RE: ARCBS 17 O’Riordan Street, Alexandria – Revised Access Arrangement

It is proposed to alter the access arrangement in the vicinity of the exit driveway to address the above concerns, in particular Item 2 of Council’s comment. The exit driveway for service vehicles and ramp to the basement would be essentially retained as per the original proposal. However, it is now proposed to reverse the flows of the entry and exit movements i.e. the entry movement from O’Riordan Street to be located on the right side of the ramp and exit movement on the left side. The revised arrangement would require vehicles leaving the basement car park to merge with the vehicles from the loading area within the site before entering O’Riordan Street. This way the number of exit points on O’Riordan Street would be

19.0M SEMI TRAILER IN

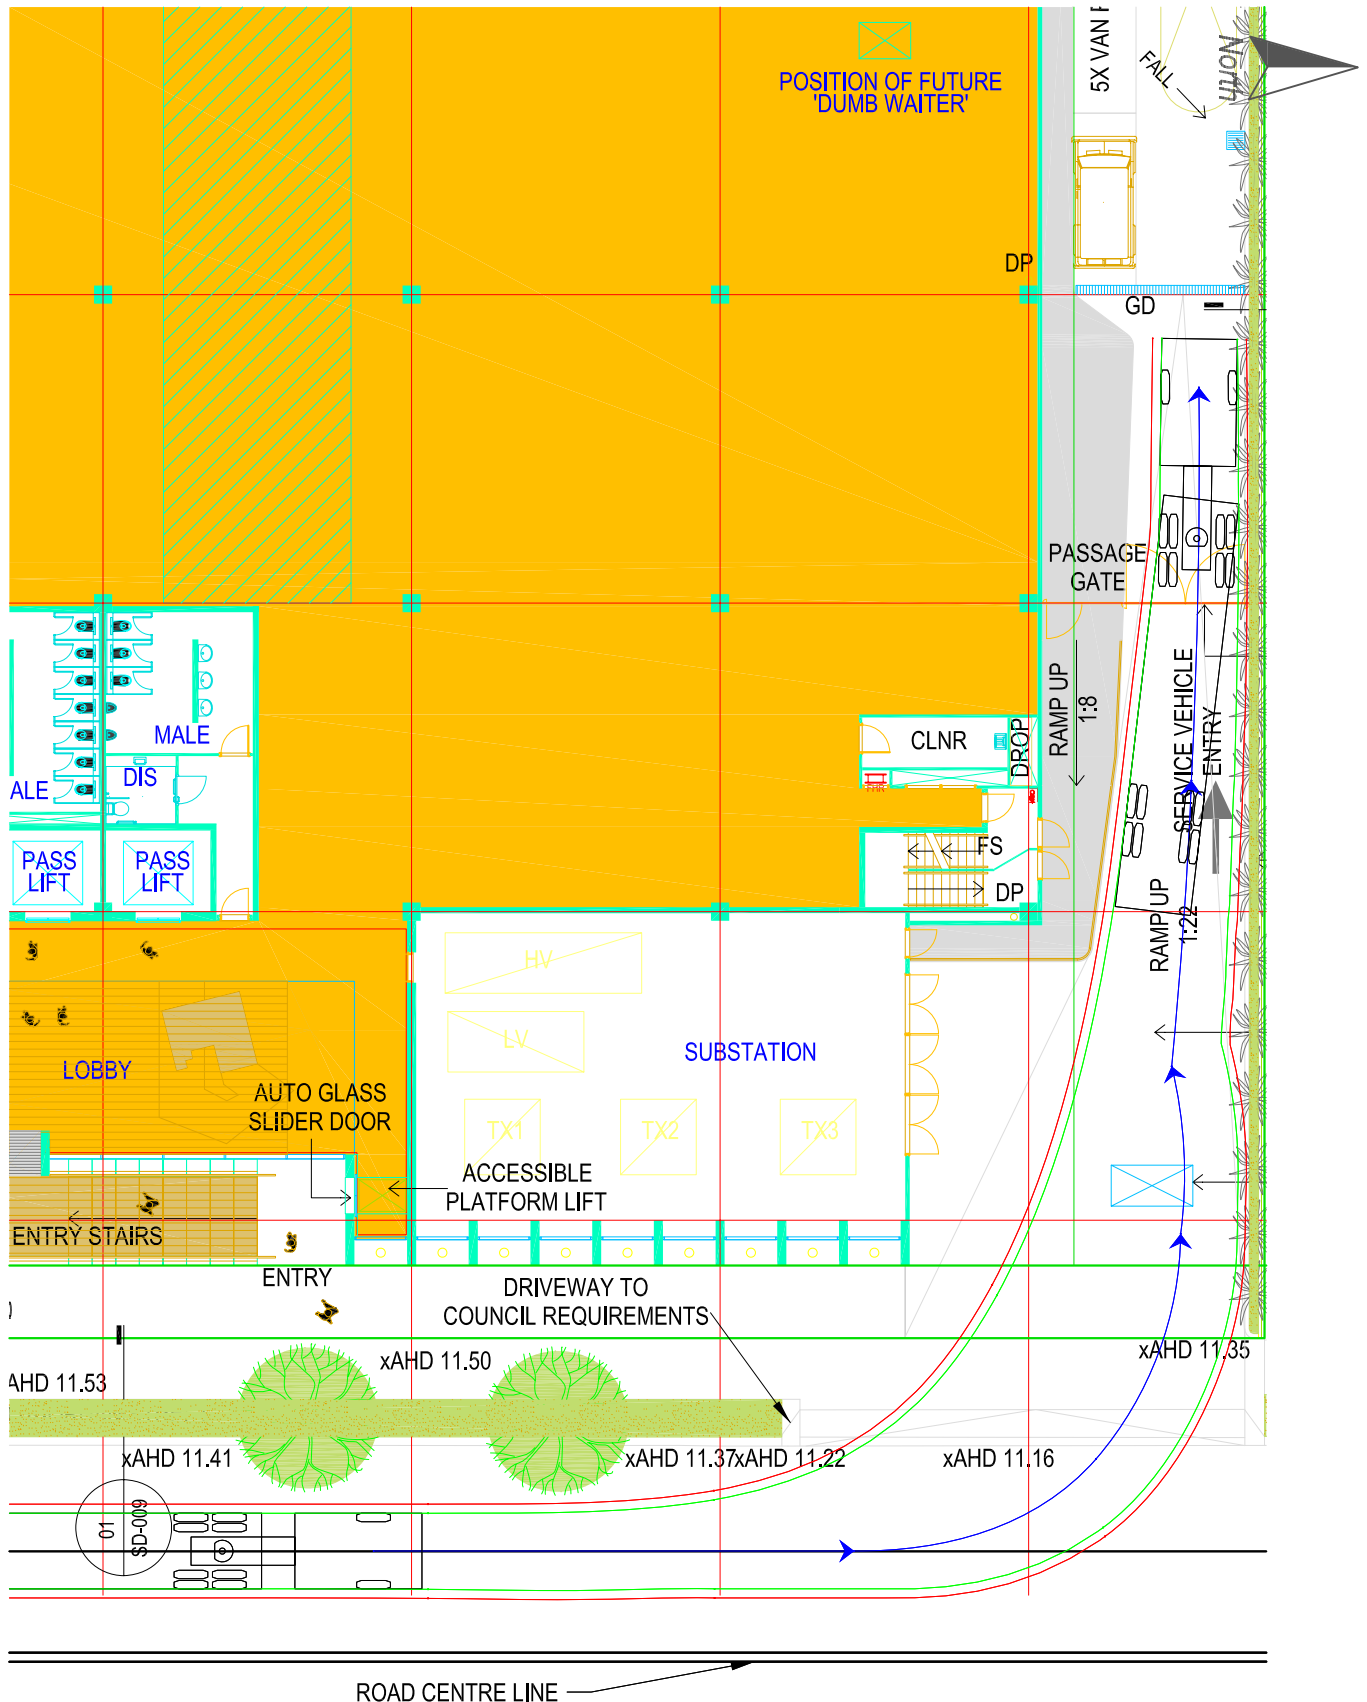
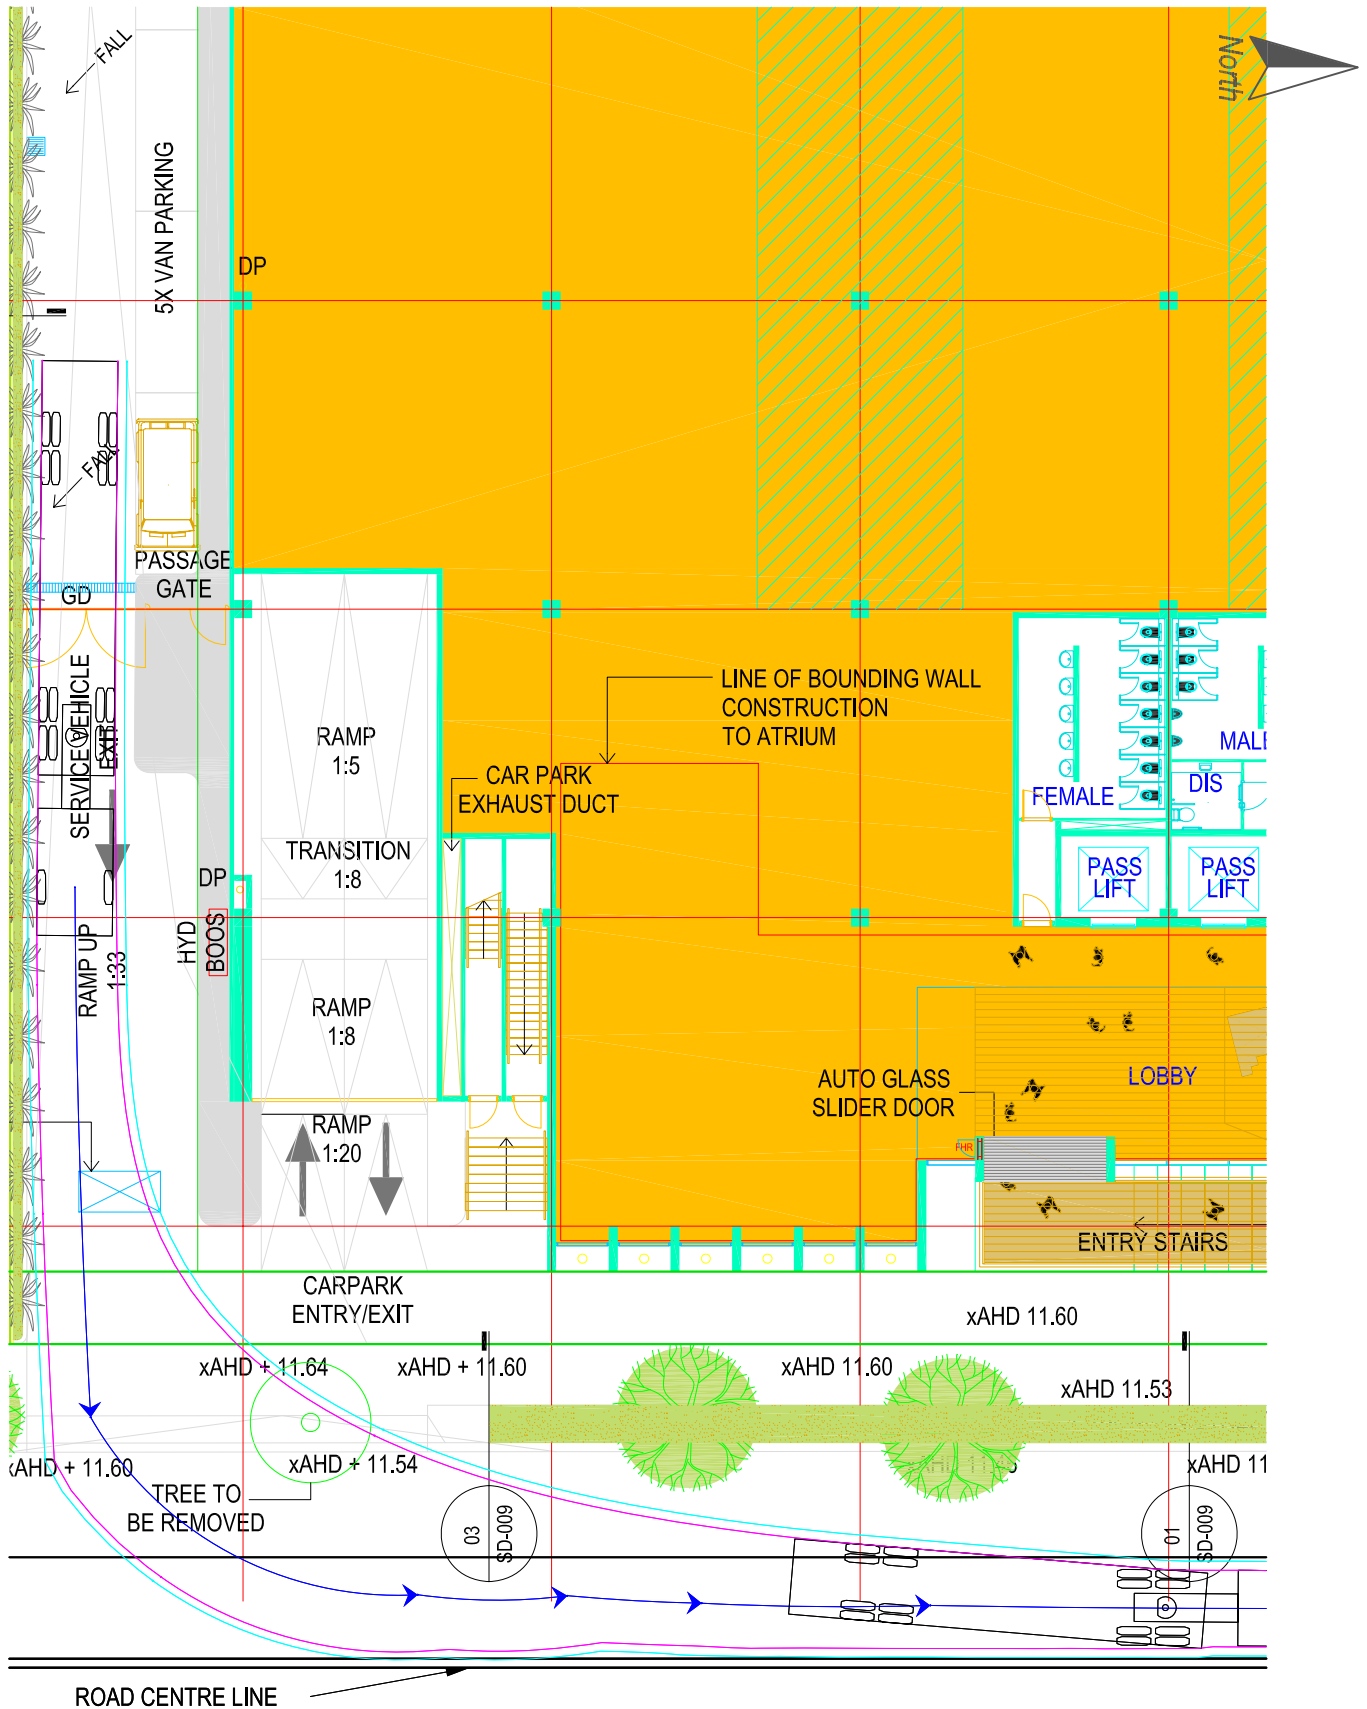
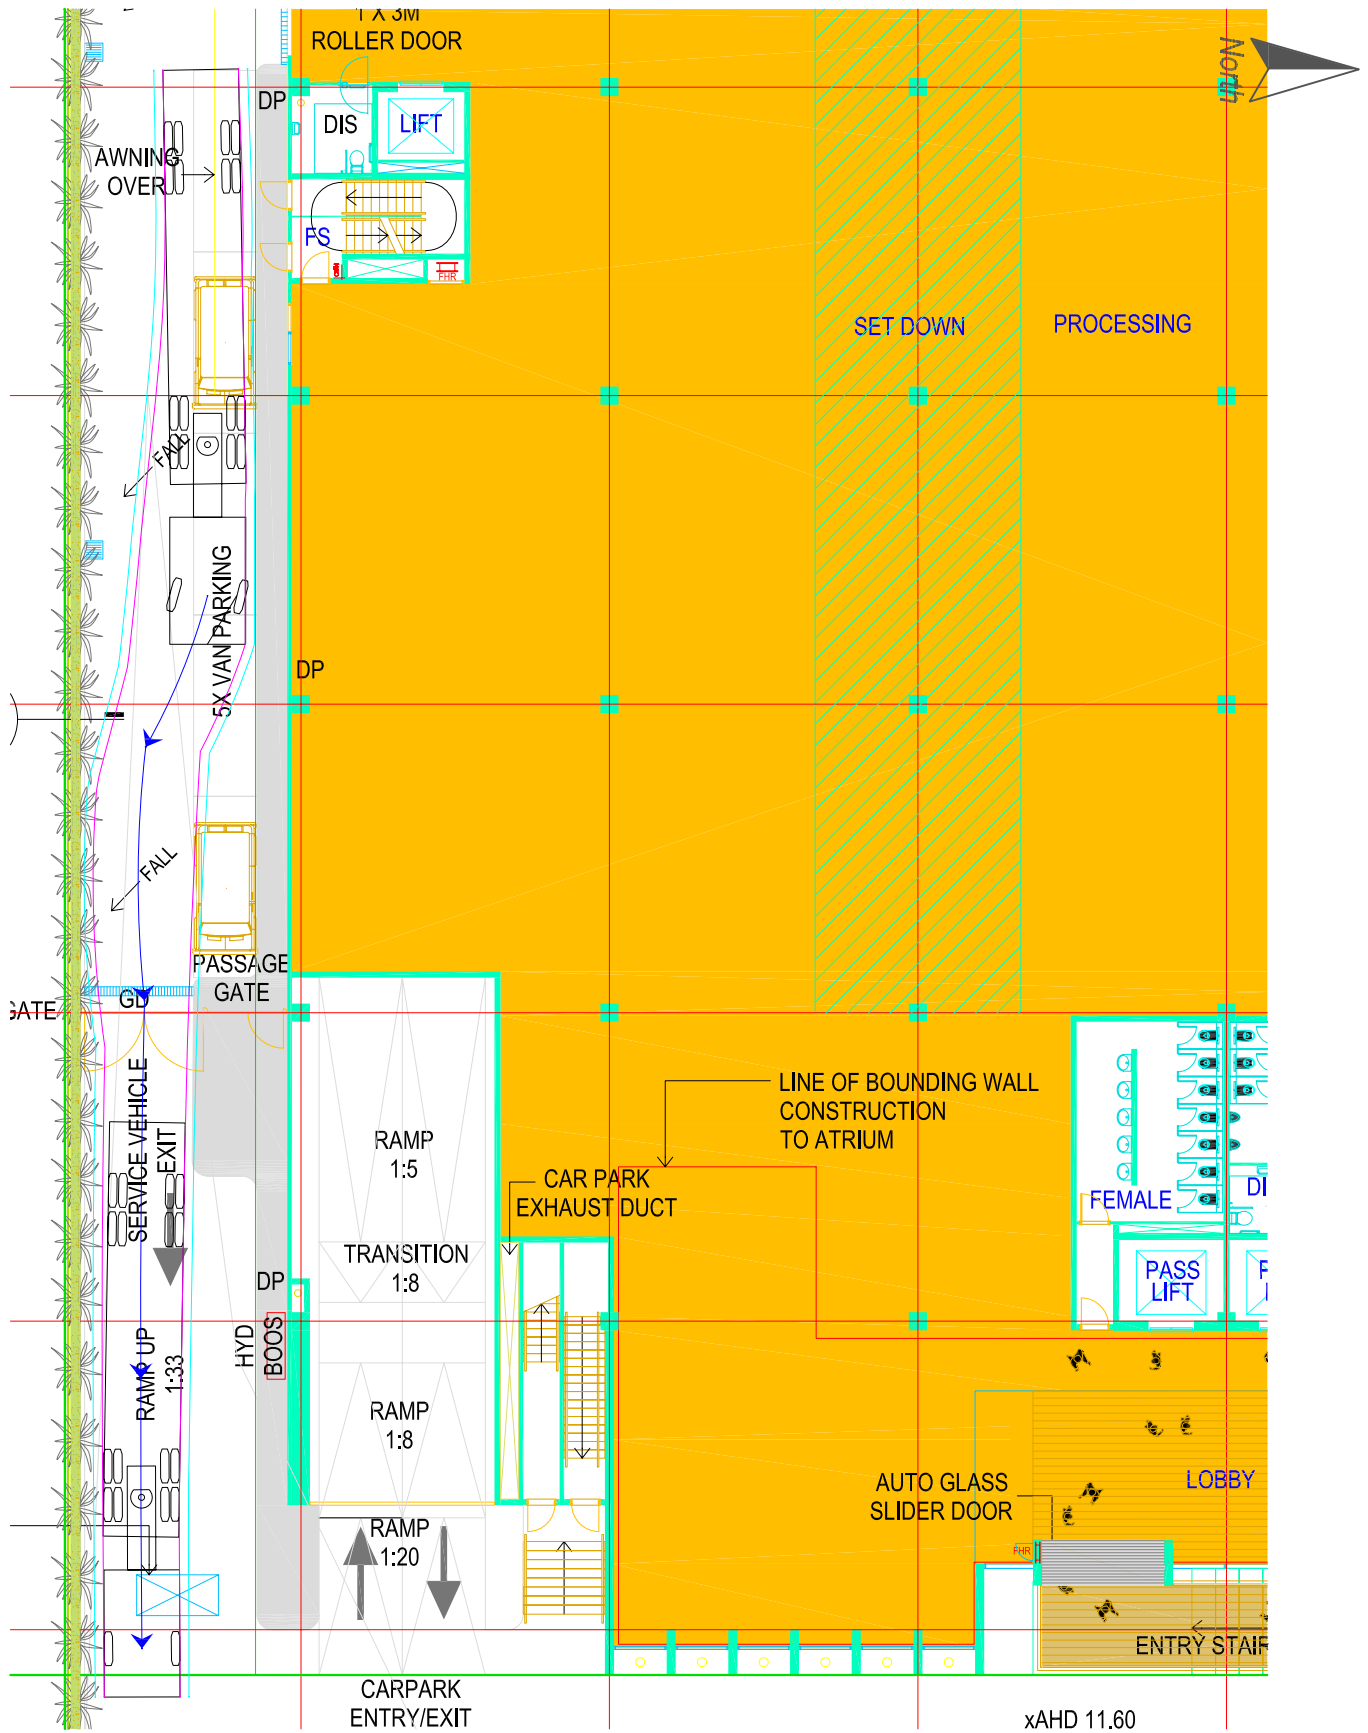
- Item 1 – the design and construction of the entry/exit driveways off O’Riordan Street shall be in accordance with AS2890.1:2004 and AS2890.2:2002;
- Item 4 – any boom gates are to be located in accordance to AS2890.1:2001; and
- Item 5 – proposed landscaping/fencing must not restrict sight distance to pedestrians and cyclists along O’Riordan Street.

- Item 1 – adequate turning area is to be provided at the end of the two-way, circulation path in the basement parking level;
- Item 2 – the proximity of the proposed driveway for service vehicle exiting the site and the driveway providing access to the basement level creates safety concern for both pedestrians and basement vehicles.

reduced from two to one and allow a pedestrian refuge island to be located between the entry ramp and the exit driveway.

The revised access arrangement has been designed in accordance with AS2890.2:2002 to accommodate 19.0m articulated vehicles. Similarly, the ramp to the basement car park has been designed in accordance with AS2890.1:2004.
